Our ref: Sydney Olympic Park new high school-Mod-2 (SSD-11802230-Mod-2)

13 January 2025

Subject: Response to Submissions - Sydney Olympic Park new high school-Mod-2

Figure 2 - Construction stage 1

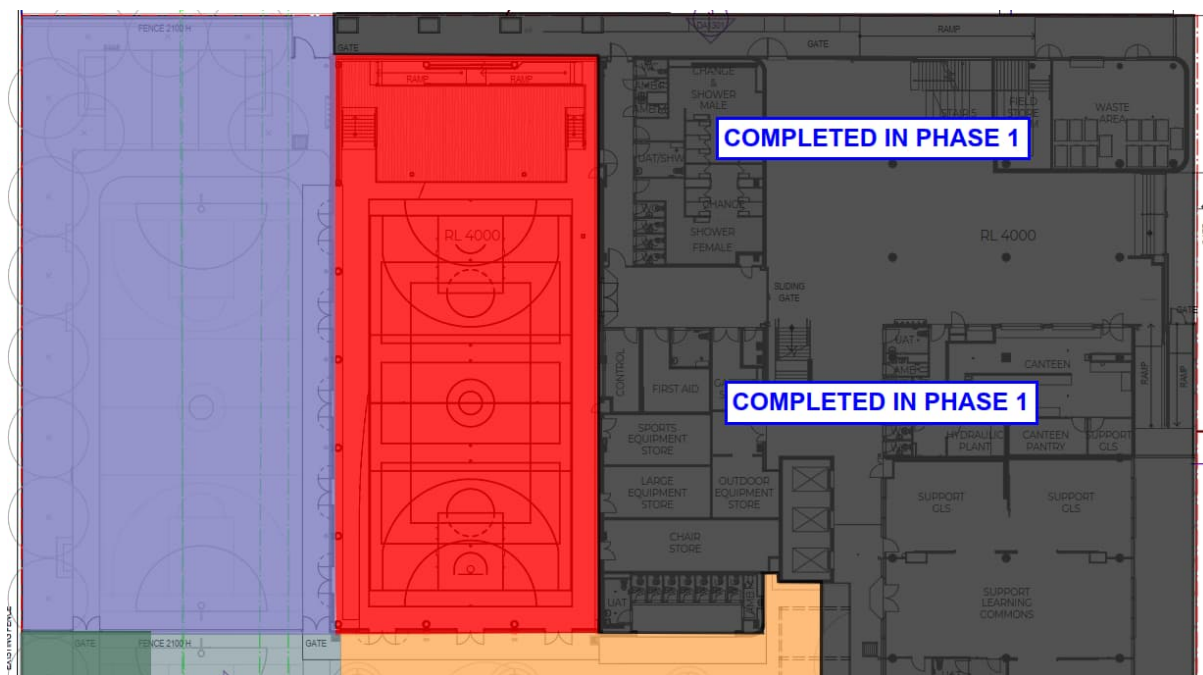
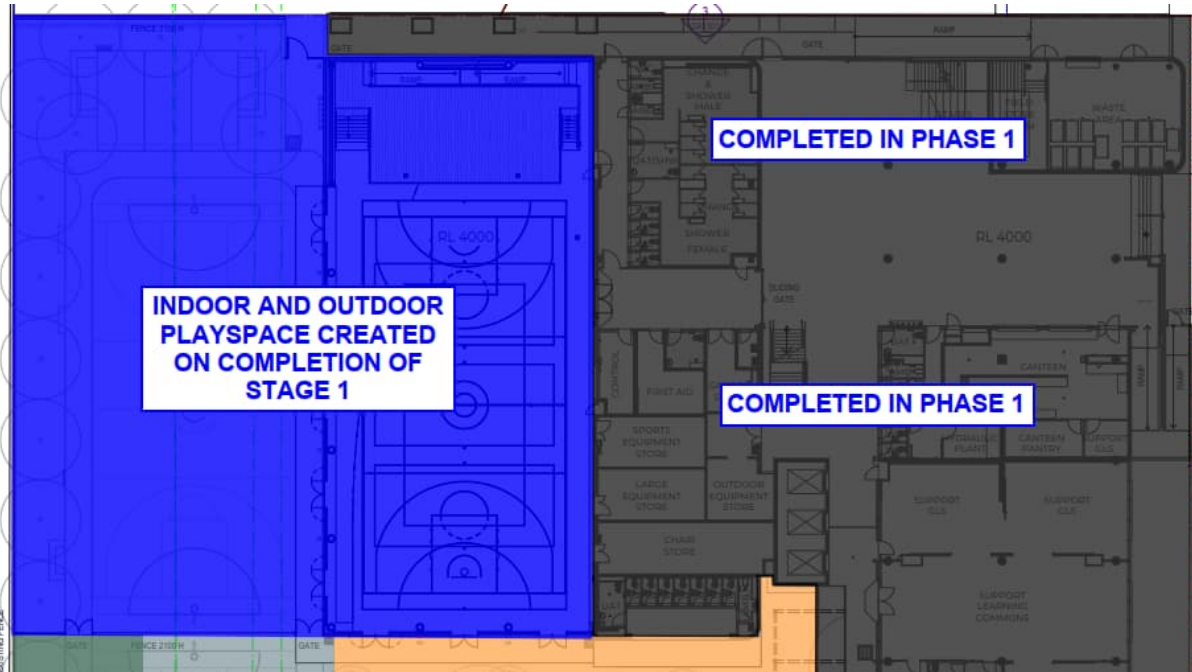
- The Department notes that plywood hoarding is to be utilised to separate construction zones and active sections of the school. The modification application has not sufficiently demonstrated whether the hoarding also acts as part of the management and mitigation measures to ensure no detrimental noise intrusion impacts to school users during the concurrent construction and operation works. The RtS must include evidence prepared by a suitably qualified professional, demonstrating that construction noise intrusion to the operational school complies with the noise management levels as originally approved and does not result in detrimental impacts to students on site. Where a non-compliance is identified, the RtS must include suitable management and mitigation measures.

Sheet title  
 SSDA  
 Proposed Elevations

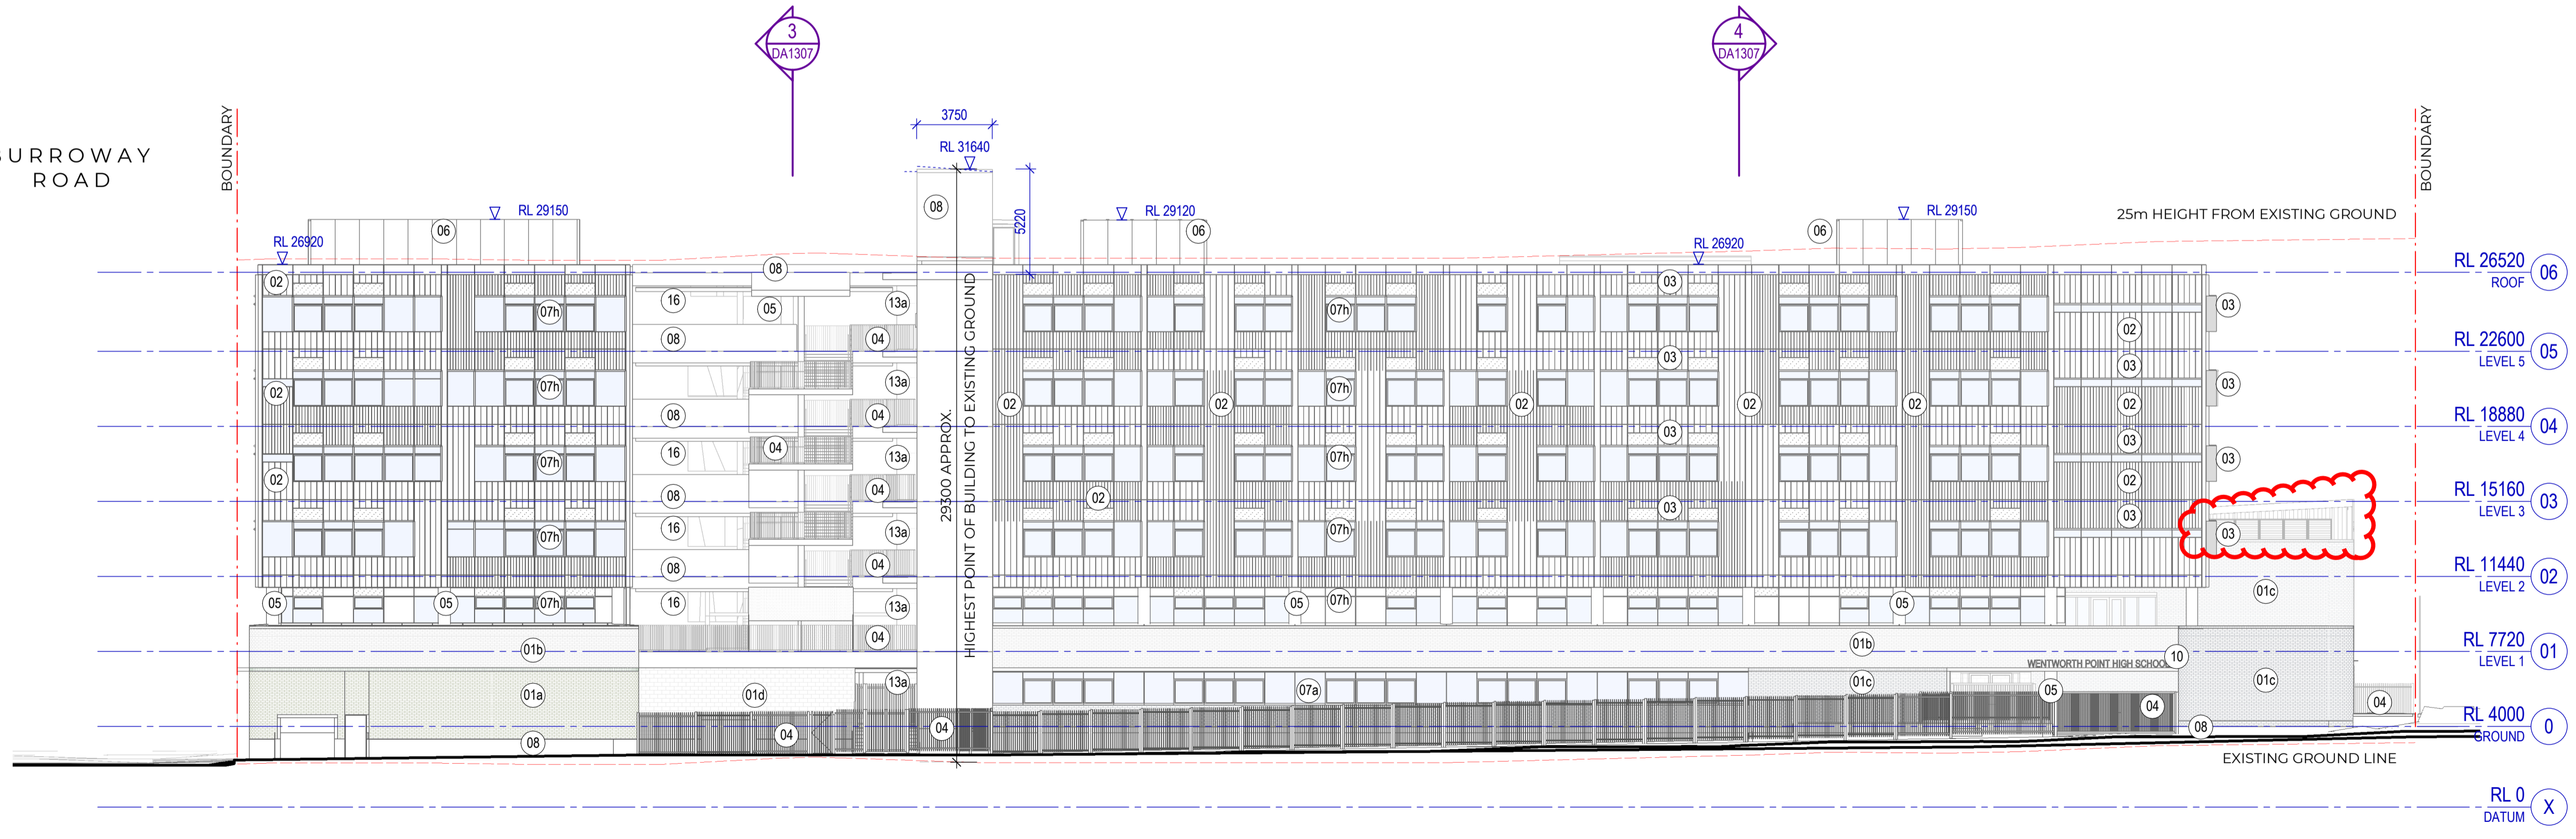
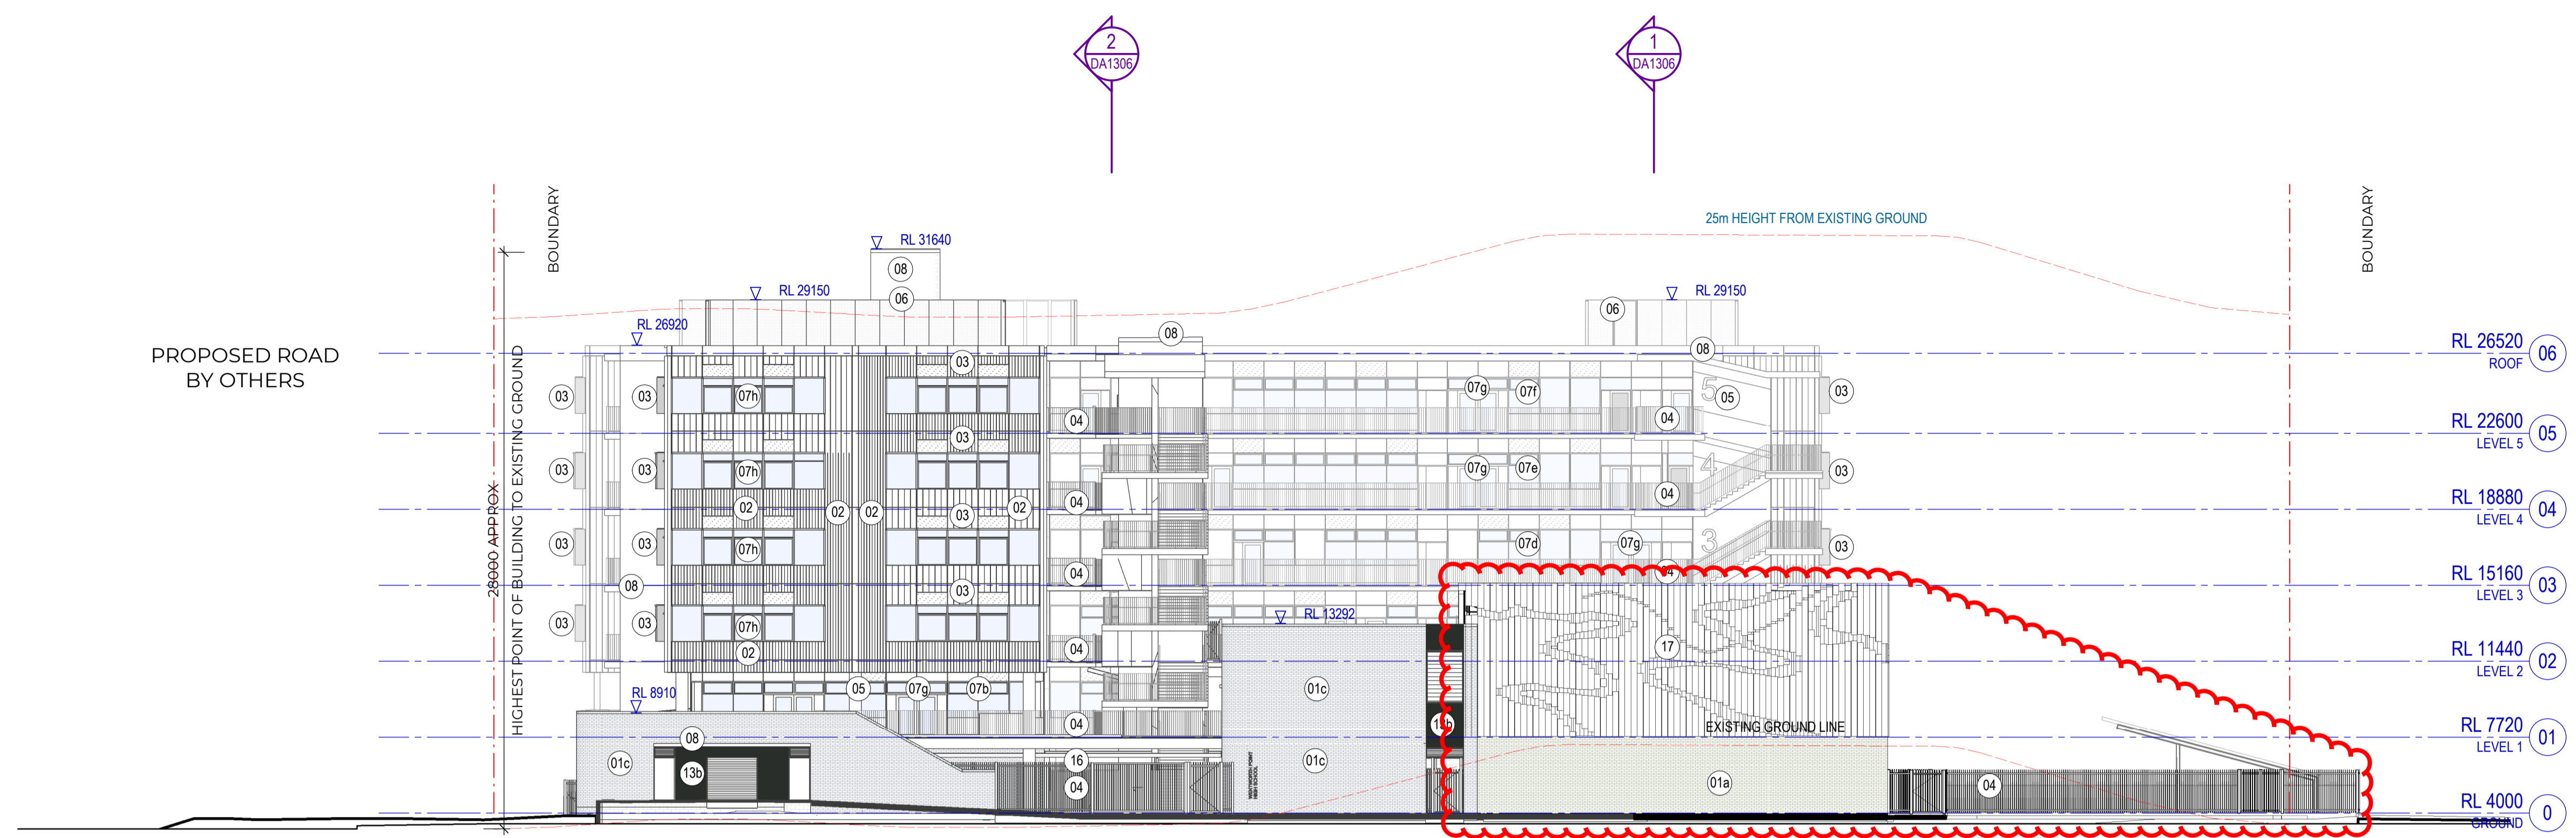
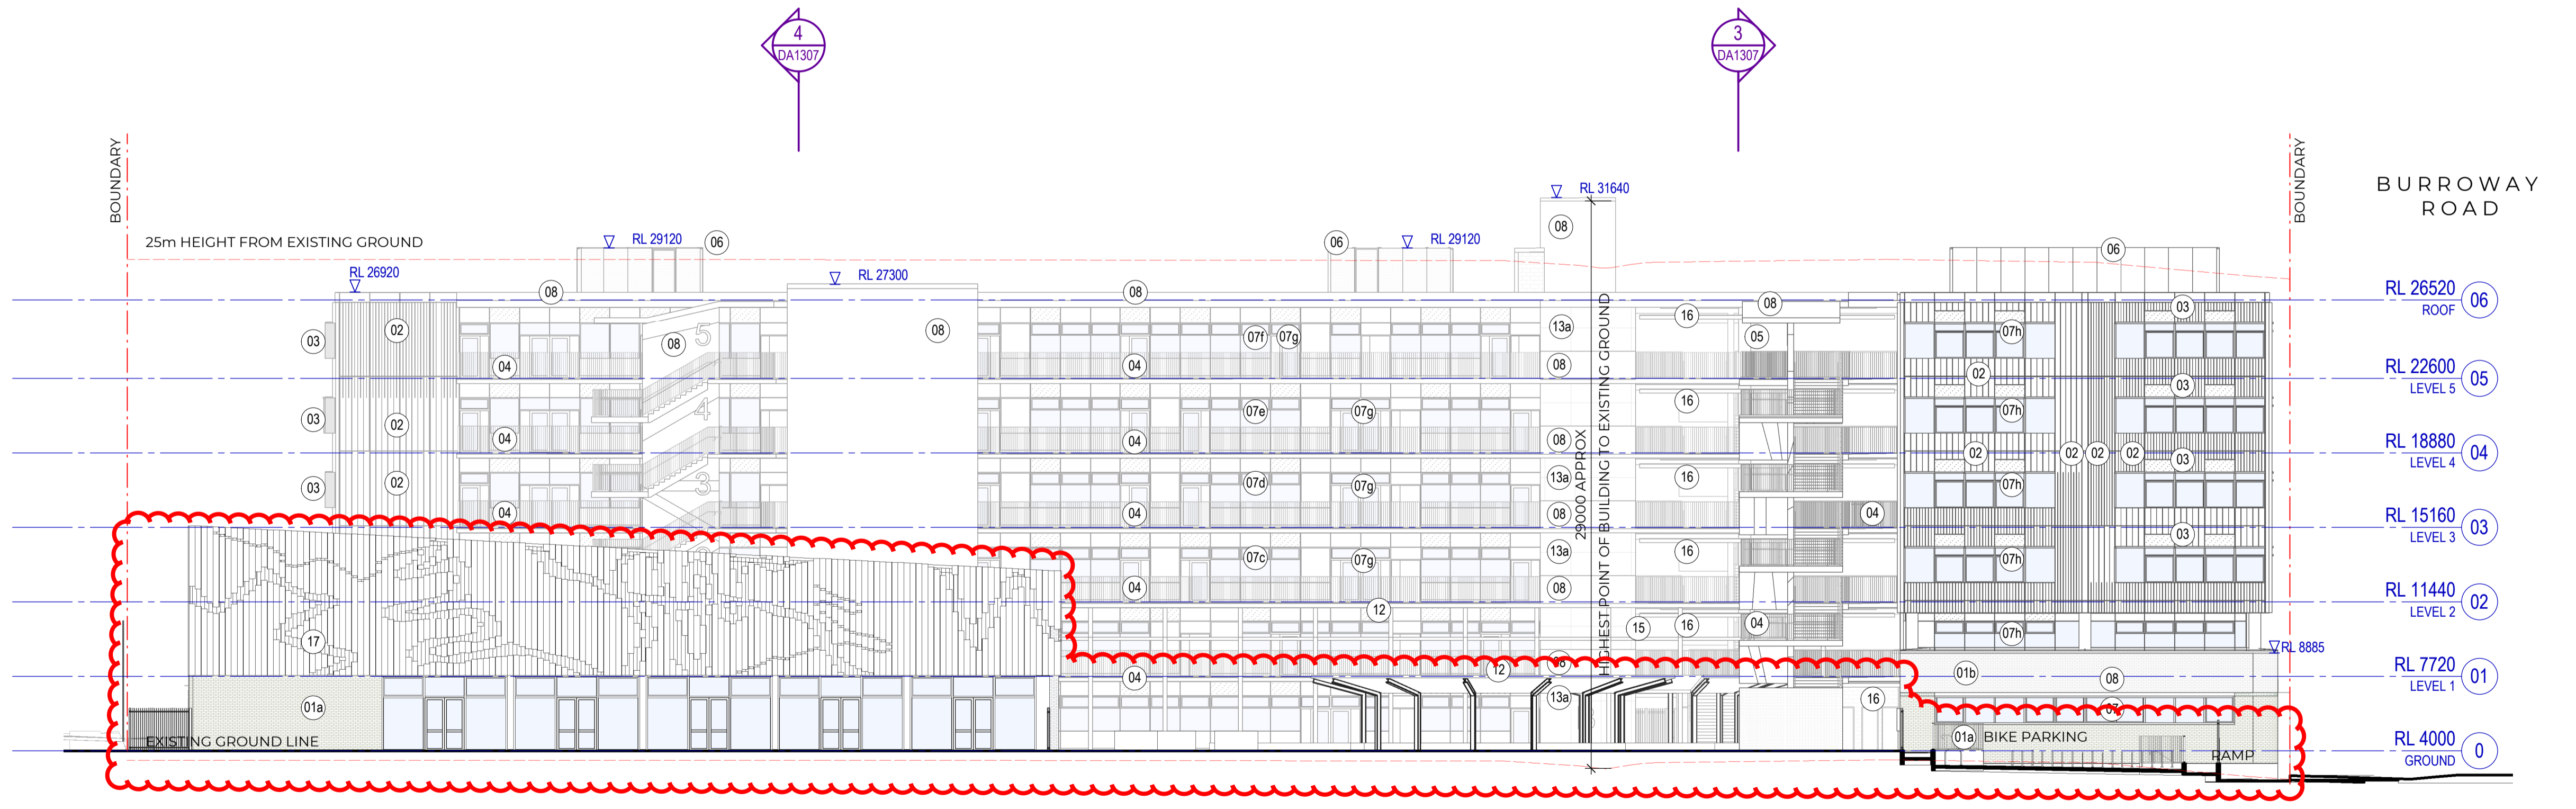
- Plans submitted with the modification application identify material number “17” for the upper cladding to the proposed gymnasium. This material is not identified on the originally approved materials schedule. The RtS must include an updated materials schedule and an illustrated plan (or photomontage) demonstrating this material treatment and associated “meandering” pattern.
